From: [REDACTED]
Sent: 24 October 2021 17:04
To: Planning
Subject: Planning Application no : 3/2021/0955

I have viewed Application 3/2021/0955 and wish to make a few comments.

drawing: Proposed Elevations

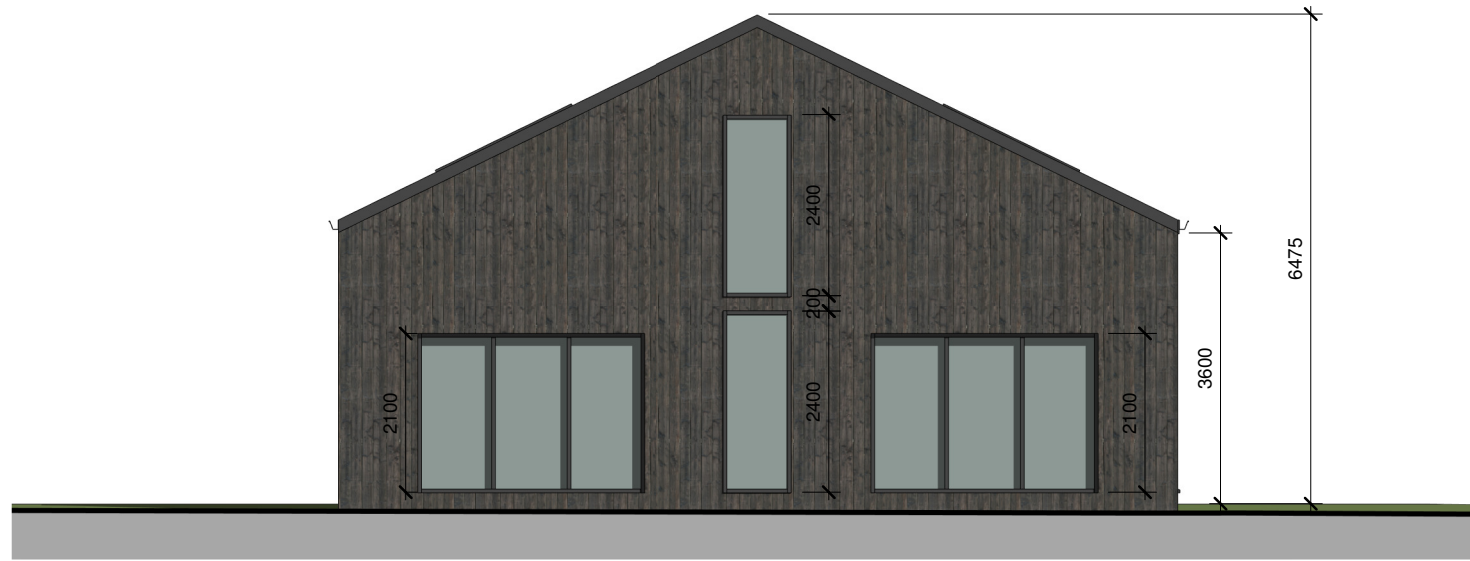
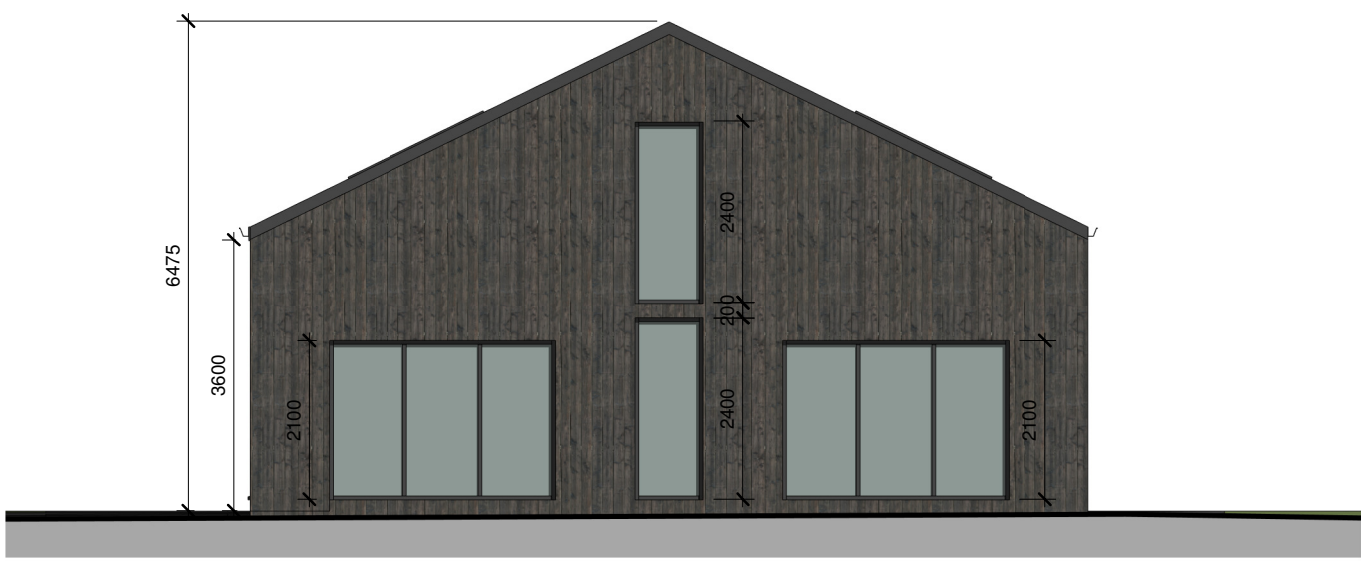
The proposed timber cladding would, I feel, be at odds with the predominantly stone walls round about.

drawing: Proposed Site Plan

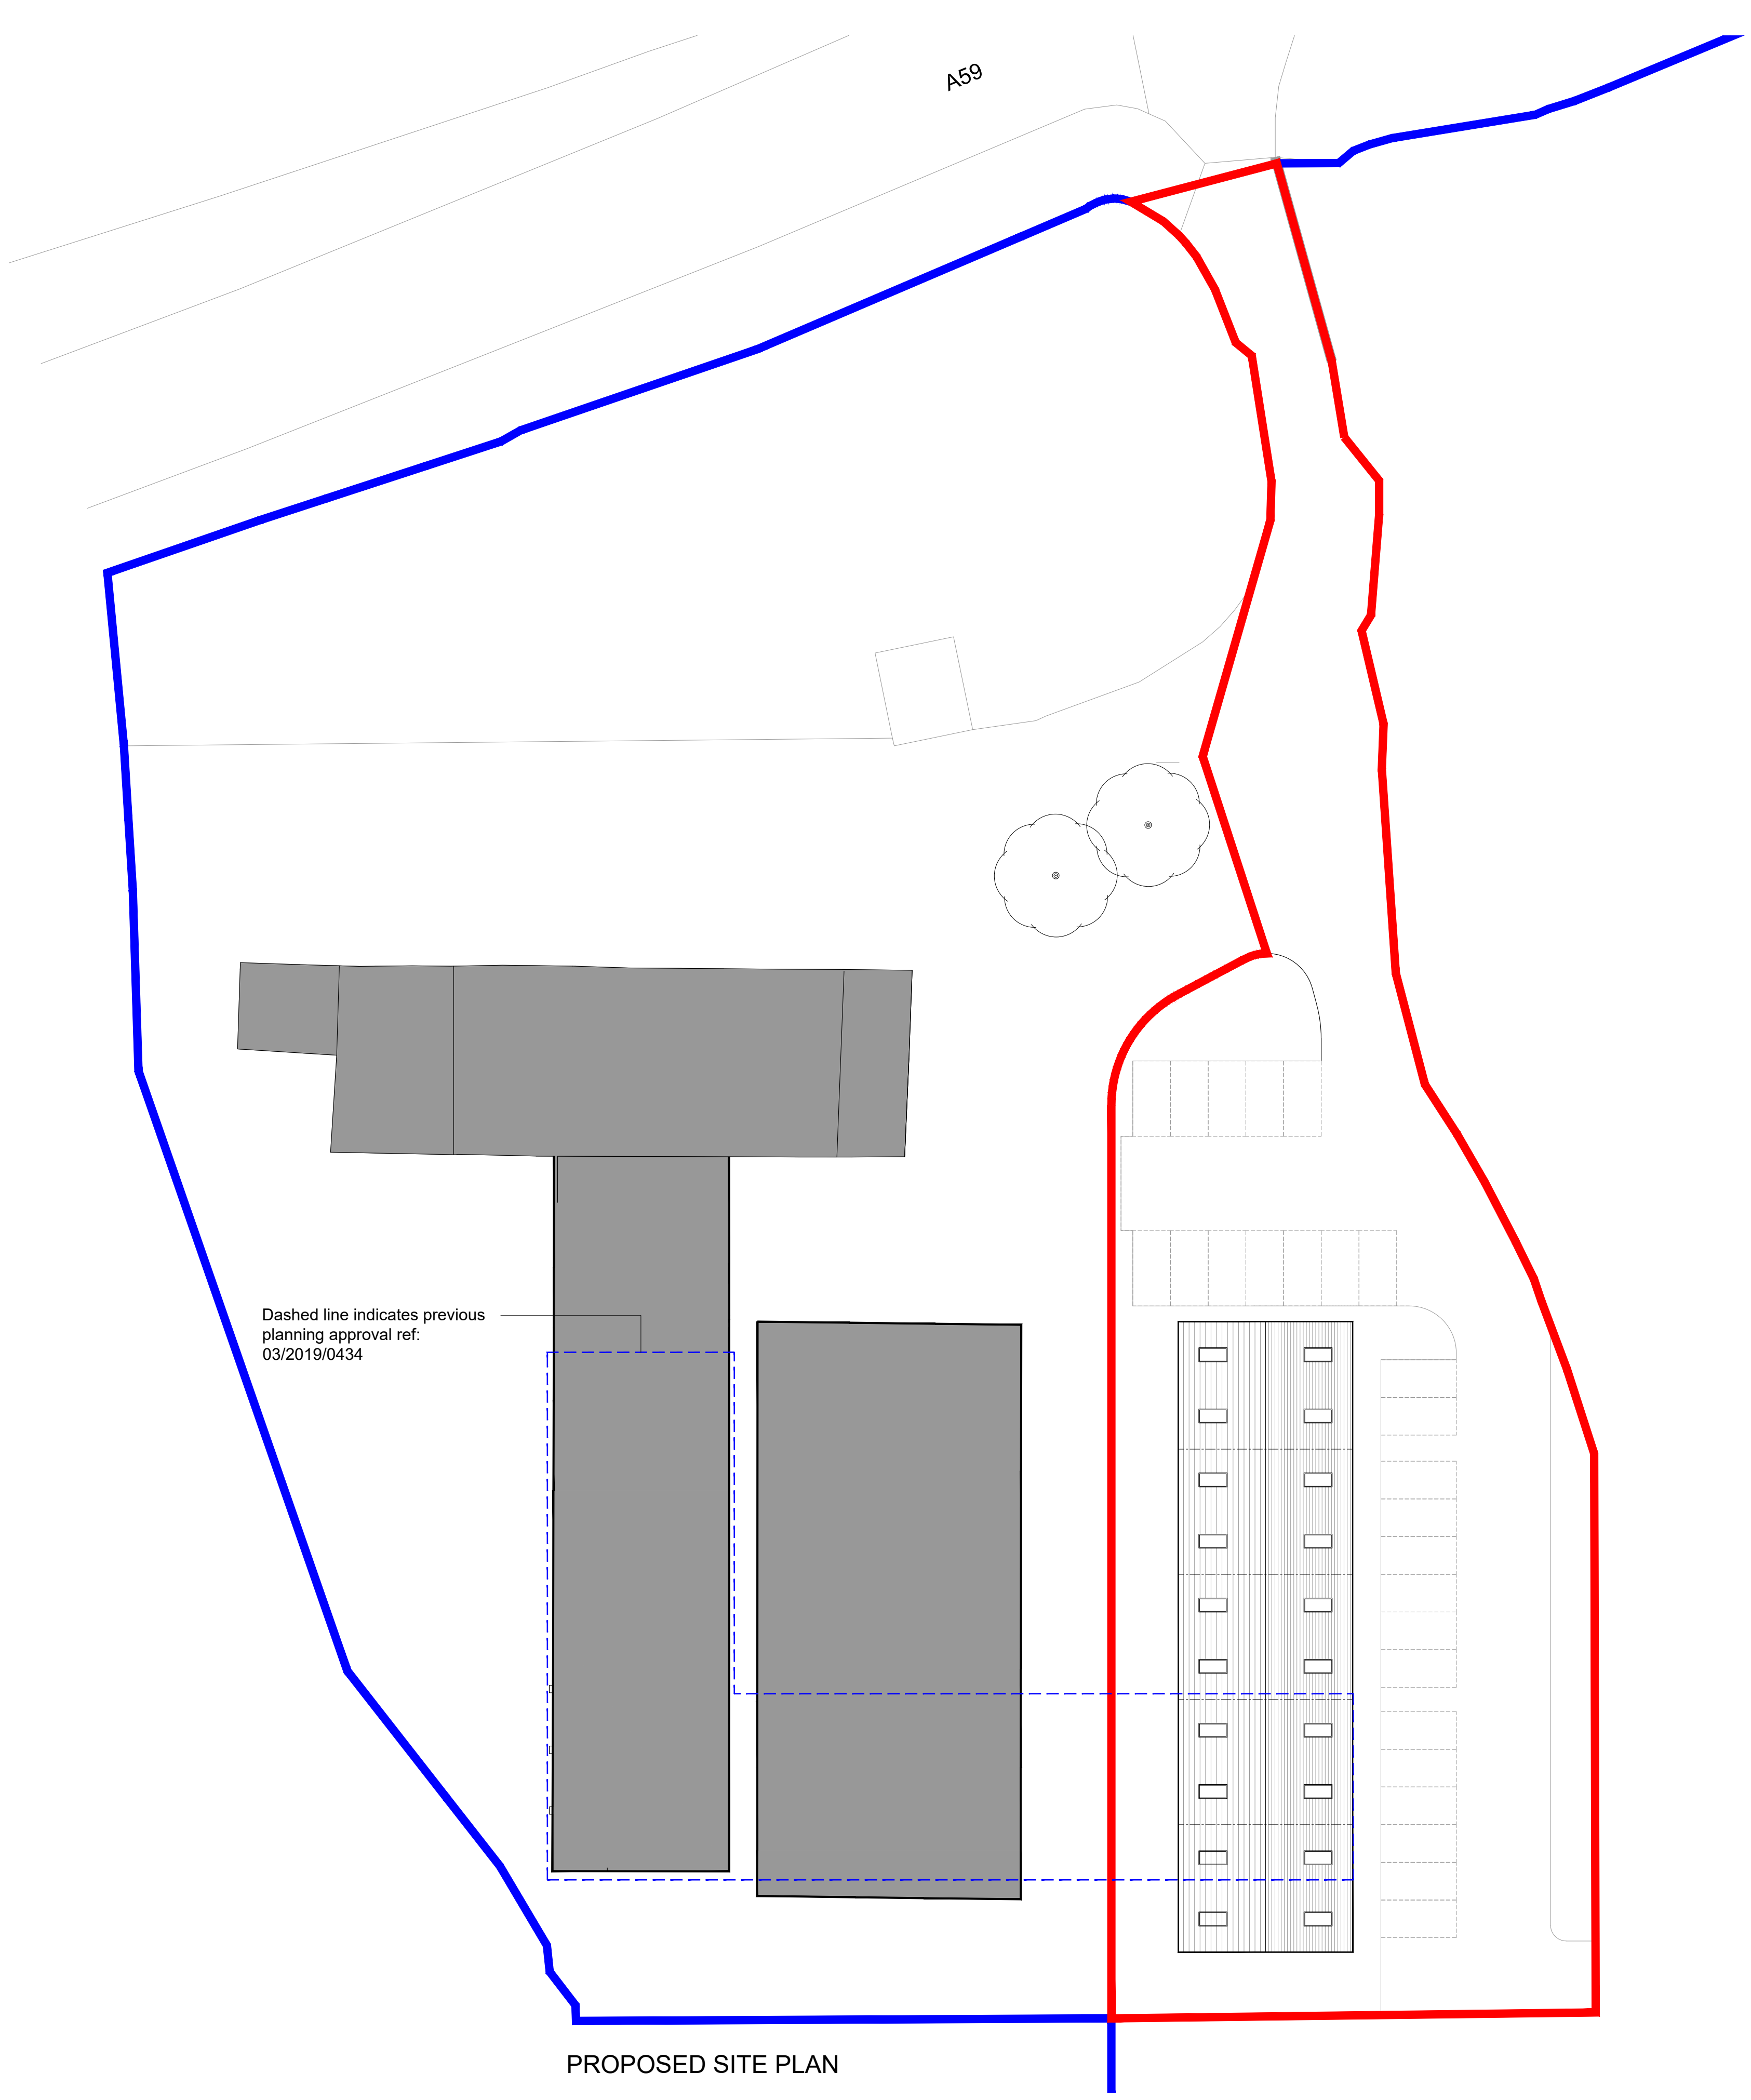
4) As I understand the last approved Application has allowed building on Greenfield protruding into the field beyond, how was this allowed to happen ?

5) Should any development allowed not be restricted to the footprint of the existing buildings ?

I am unclear why the proposed development has shifted into agricultural land, when the two unused and derelict cow sheds are left standing. These constitute an eyesore, at odds with a plan which claims a "modest, sympathetic scheme, respectful of its setting".
